November 2, 2020

Re: COA-Westside Vehicle Maintenance/Office Bldg
18000 Cerro Colorado Road SW
Traffic Circulation Layout
Architect's Stamp 10-30-2020 (P01-D001A)

Based upon the information provided in your submittal received 10-30-2020, the above referenced plan cannot be approved for Building Permit until the following comments are addressed:

1 SITE PLAN
SCALE: 1" = 50'-0"

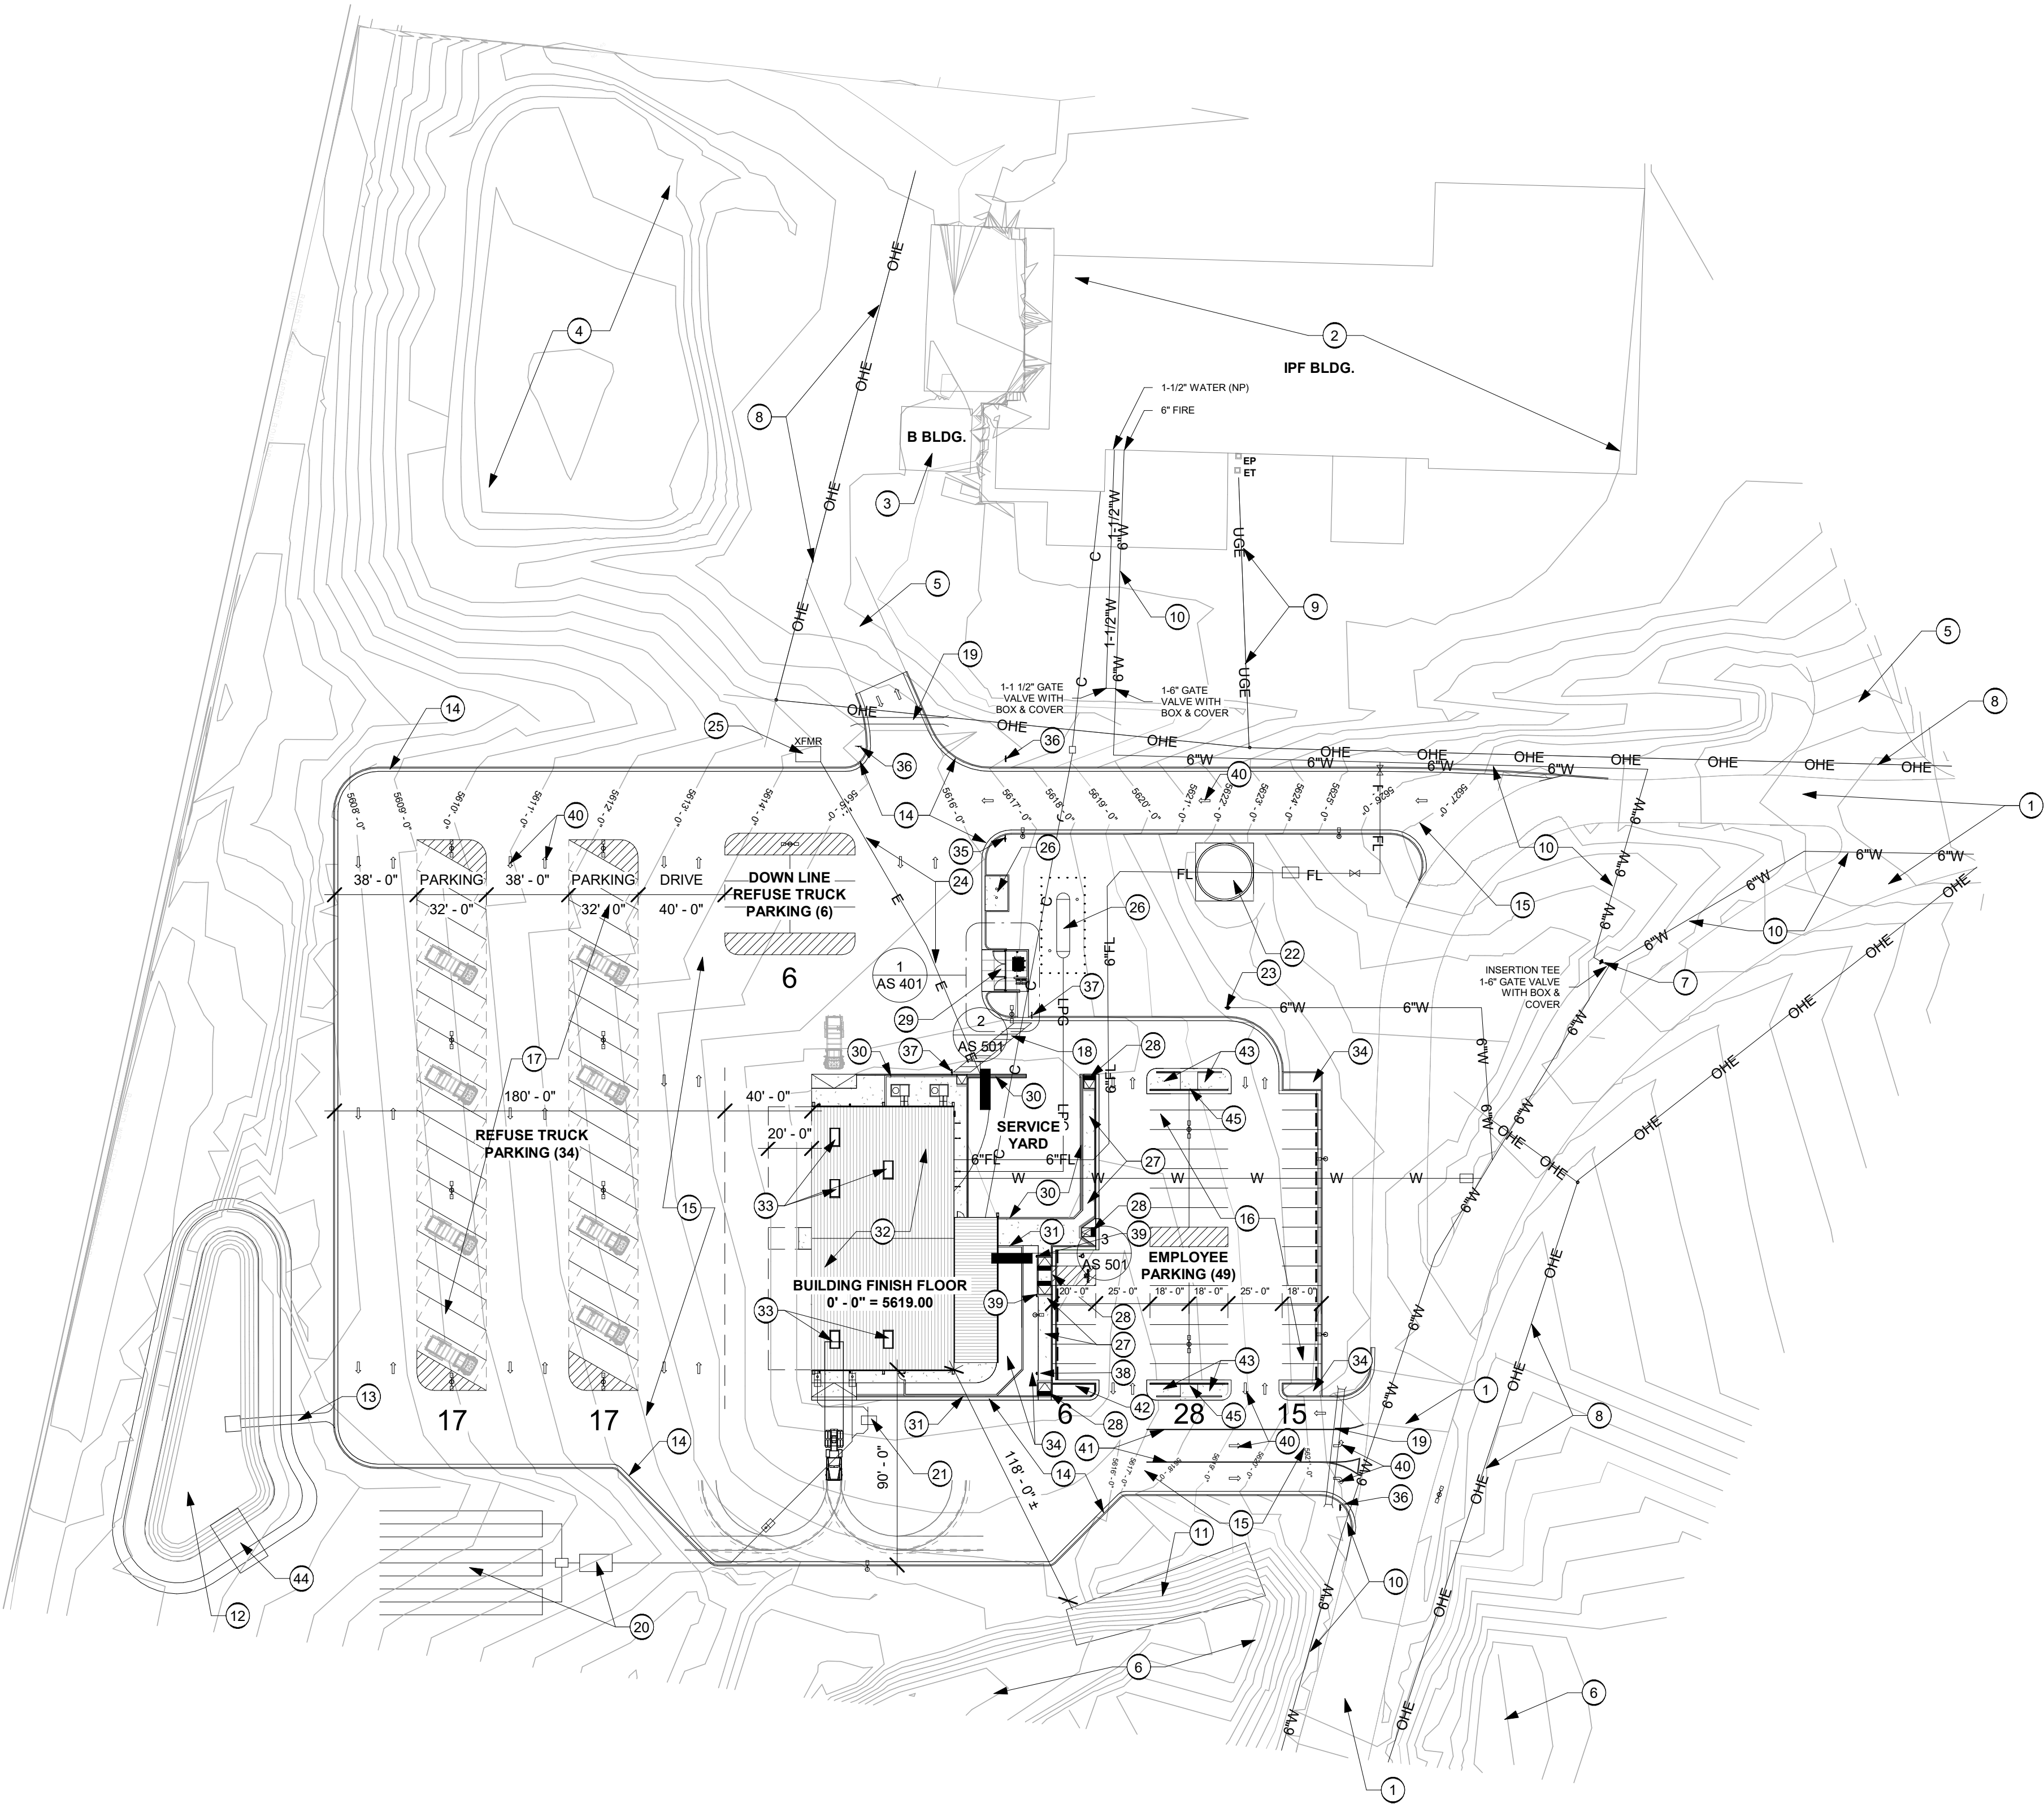
1. The listed number of parking spaces required by the zoning code as well as the proposed number of parking spaces including bicycle and motorcycle parking. All proposed required calculations need to be discussed with Zoning (**if applicable**).

2. Site Plan: Please clean up sheet showing contour lines for your submitted TCL plan.
3. Plat Status: Please provide an approved plat if the property was subdivided for this proposed site development.

4. Identify all existing access easements and rights of way width dimensions (If applicable to your site).
5. Since your accessing off a County and not a City road, please attainment an approval letter from the county. If this is not the case, then comment not valid.

6. If there are not existing curb and gutter on Cerro Colorado Road, taper the curb returns at roadway connection. Do you need 6 valley gutter at proposed entrances to the Site?

7. Please list the width and length for all existing and proposed parking spaces. Some dimensions are not shown.
8. The minimum parking stall dimensions are:

9. The ADA accessible spaces must include an access aisle. Van accessible aisles should be 8ft wide; all others should be 5ft wide.
10. The ADA accessible parking sign must have the required language per 66-7-352.4C NMSA 1978 **"Violators Are Subject to a Fine and/or Towing."** Please call out detail and location of signs.

12. Motorcycle parking spaces shall be designated by its own conspicuously posted upright sign, either free-standing or wall mounted per the zoning code. Label pavement MC.

17. Show all drive aisle widths and radii. Some are not shown.
18. List radii for all curves shown; for passenger vehicles. **Radius for delivery trucks, fire trucks, etc. is 25 ft. or larger.**

19. A 5 ft. keyway is required for dead-end parking aisles.
20. Per DPM, a 6 ft. wide ADA accessible pedestrian pathway is required from the ADA parking stall access aisles to the building entrances. Please clearly show this pathway and provide details.

21. Curbing should be installed to delineate landscape, parking, and pedestrian ways and identify points of access. **Please call out detail** and location of barrier curb.

25. Please provide a sight distance exhibit
26. Show the clear sight triangle and add the following note to the plan:
"Landscaping and signage will not interfere with clear sight requirements. Therefore, signs, walls, trees, and shrubbery between 3 and 8 feet tall (as measured from the gutter pan) will not be acceptable in the clear sight triangle.
